RE: RU-25-00004 Thomas

SUBJECT: WDFW COMMENTS ON RU-25-00004 Thomas

Thank you for the opportunity to review and comment on Kittitas County reasonable use application RU-25-00004 Thomas, a proposal to construct a single-family residence, an outbuilding and associated infrastructure on Kittitas County parcel 186635. The Washington Department of Fish and Wildlife (WDFW) has reviewed the application materials on file and our comments are regarding the project's impact on Fish and Wildlife Habitat Conservation Areas (FWHCAs, CAO Chapter 17A.04), specifically riparian habitat.

Above: Proposed site plan with added buffer as mitigation for buffer impacts.

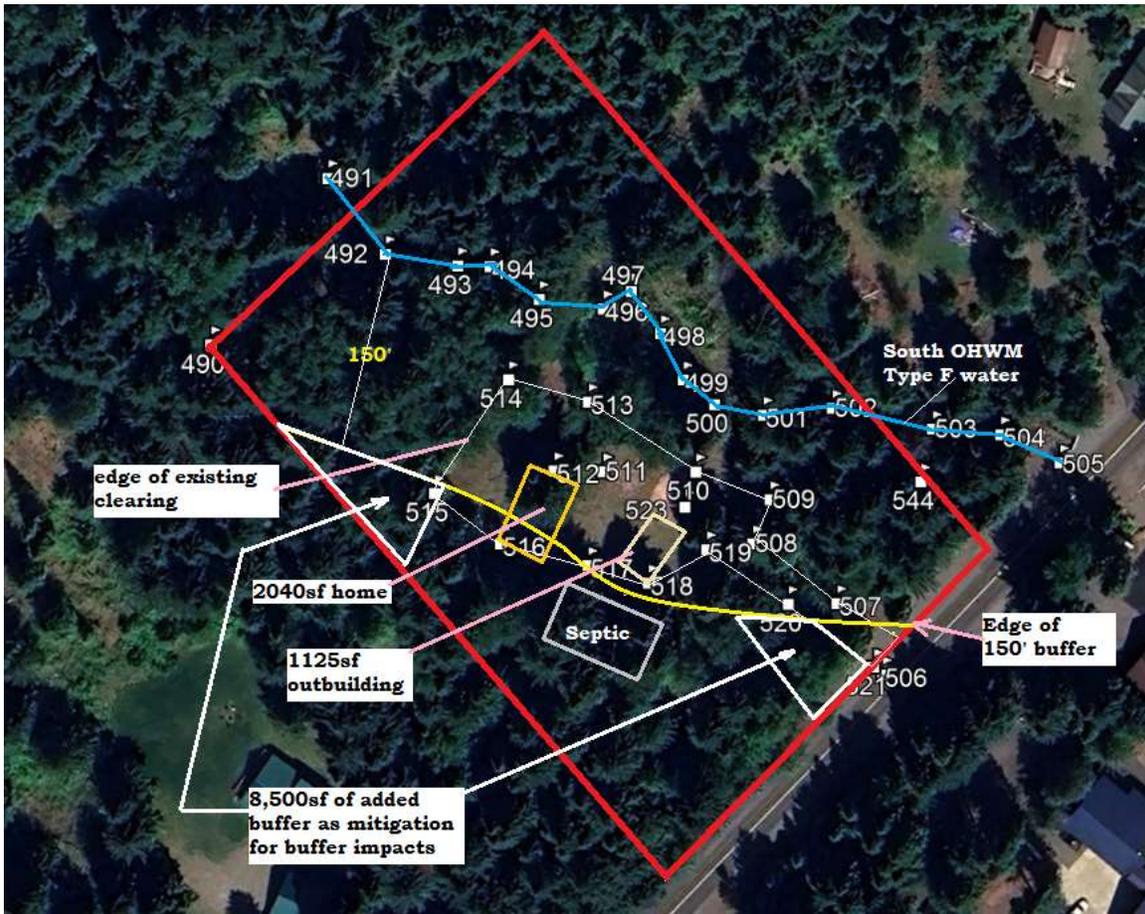
To ensure no net loss of the RMZ, we recommend the mitigation sequencing of avoidance, minimization and ultimately mitigation. We recommend avoiding and minimizing impacts to the riparian management zone by siting the new infrastructure as far away from the stream as possible and reducing the development footprint as feasible. Where impacts cannot be avoided, mitigation will be needed to offset the impact to the stream's riparian buffer.

The critical areas report notes two different values for the permanent development impact (8,841sq ft and 8,481sq ft) and references the prior County CAO Standard RMZ widths for buffer protection. The critical areas report proposes to compensate for the permanent impact by adding 8,500sq ft to the riparian buffer on the southern portion of the property using buffer averaging. We don't see a plan/exhibit included with the application materials that specifically identifies where the 8,500sq ft proposed addition to the existing buffer is located. Further, WDFW believes preservation alone doesn't achieve no net loss. Are stream or riparian enhancements included in the proposal? Is the area fully within the RMZ identified by SPTH? How will the area be protected in perpetuity? We request additional information on the proposed mitigation to evaluate the adequacy and ensure no net loss of the riparian buffer function and value.

We recommend development of a mitigation plan, to be reviewed and approved by WDFW prior to construction, as a condition of the reasonable use determination. The mitigation plan should quantify the proposed mitigation measures and demonstrate equivalent or greater biological functions of FWHCAs consistent with Kittitas County's Critical Areas Ordinance (CAO 17A.04.070). If developing a planting plan, it should include monitoring to ensure survivability of the planted plants. We recommend at least three years of monitoring with an 80% survivability. If metrics fall below 80%, we recommend that similar plants be planted to replace those that did not survive.
